CITY OF ALBUQUERQUE

March 18, 2019

Site: Ladera Self Storage-2100 Ladera Rd NW

Re: Drainage Ordinance (14-5-2-1) Violation for Erosion and Sediment Control and Construction Site Waste(s)

### Erosion Control Notes

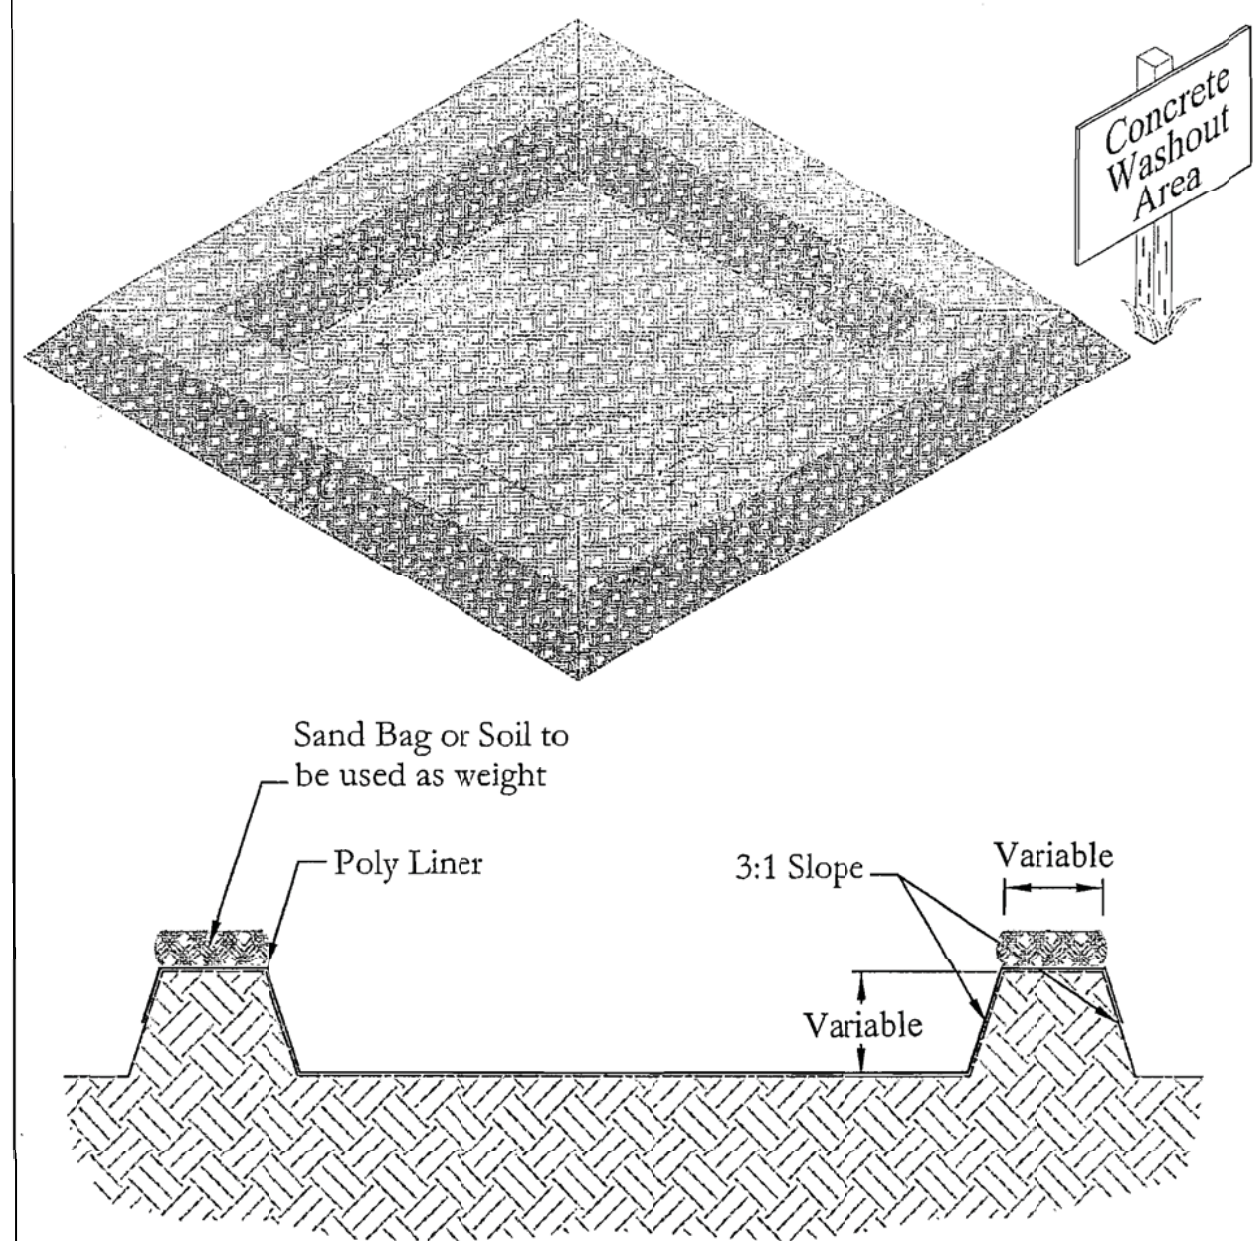
1. Dirt pile too high above and against silt fence.
2. Construction site wastes not in an acceptable waste container.

Dirt pile too high above and against silt fence.

1. Remove dirt from silt fence where it is higher than 50% of the height of the silt fence and repair silt fence if necessary.
2. Maintain silt fence(s) so the grade does not exceed 50% of the height of the silt fence(s) and so that the silt fence is not bulging.
2. Place construction site wastes in an acceptable waste container and have workers use the waste containers in the future.
